CHALLENGER HOMES
FALCON HIGHLANDS SOUTH
EL PASO COUNTY, COLORADO
CONSTRUCTION PLANS
GRADING AND EROSION CONTROL PLAN
INITIAL GECIP

A 1st SUBMITTAL TO EPC
07/29/2022 - RDL

COUNTY FILE NO.:
PUDSP-22-005

4

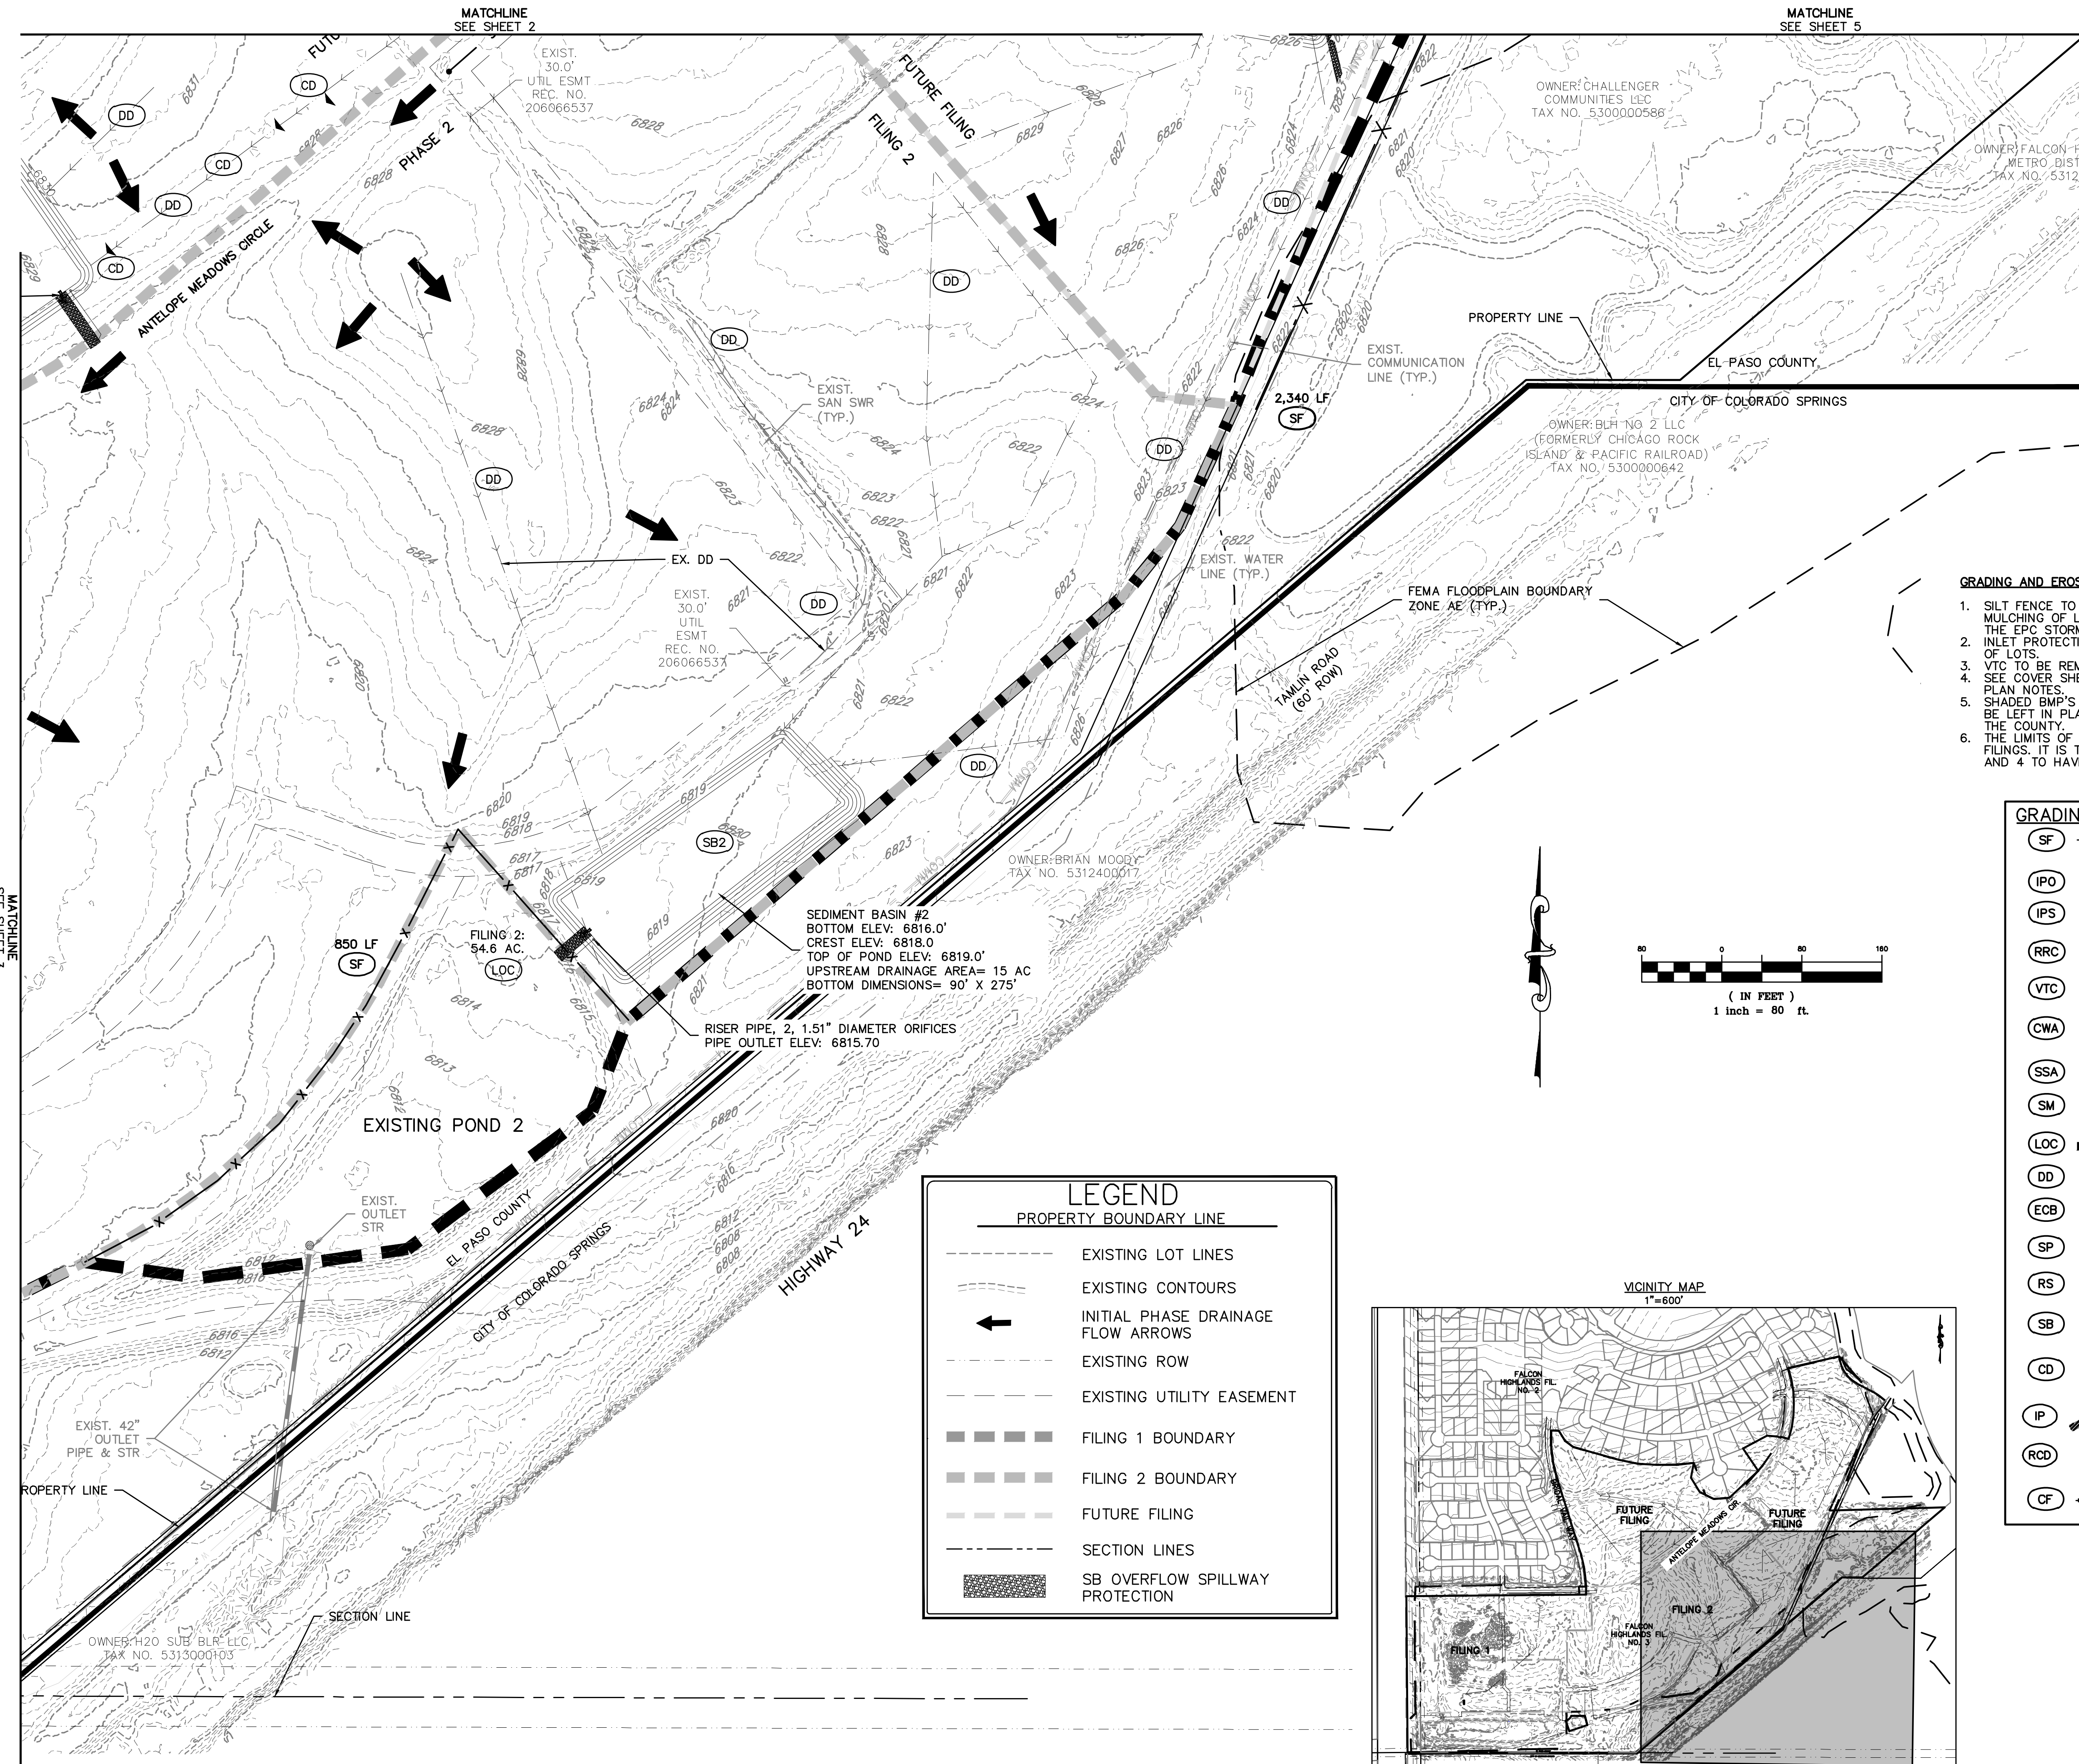
remove, does not
match note on cover of
GEC and DR text

Removed

JOB: 21005234
SHEET NO. 6

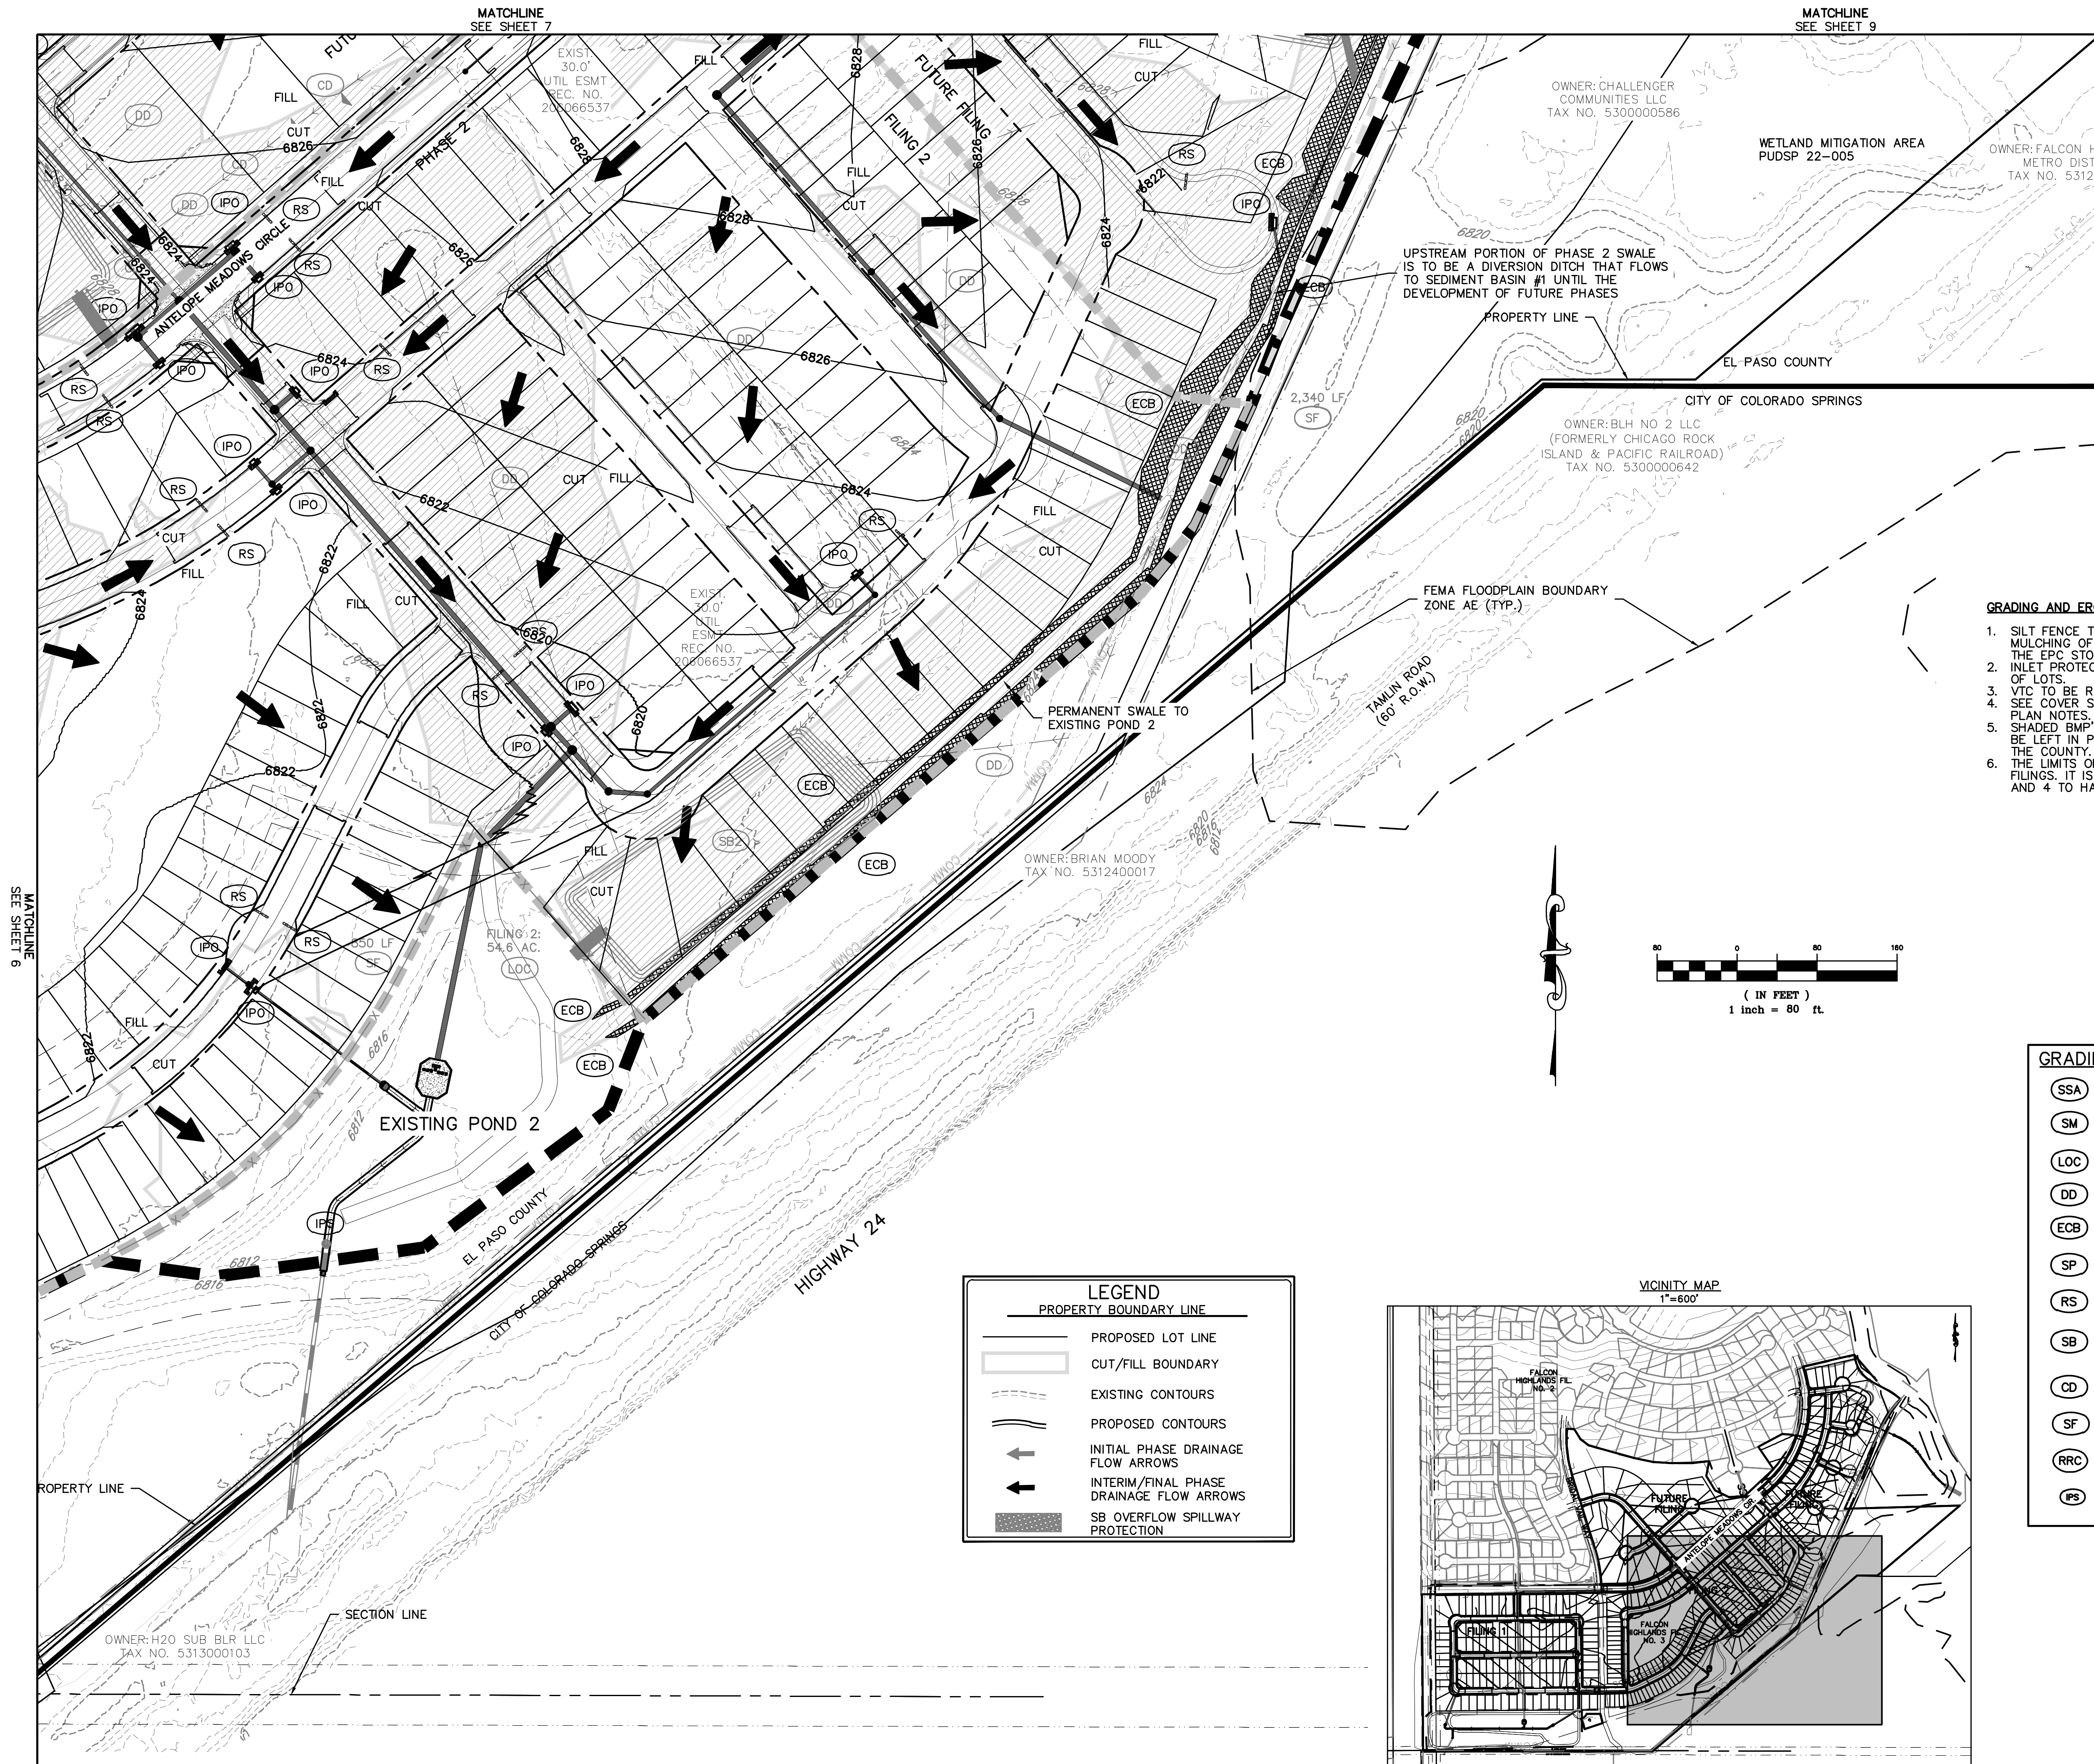
some of these arrows seem to be pointing in the wrong direction

please match interim and final plans to the same order as the initial sheets

show
proposed
flows

Revised

Revised

Revised
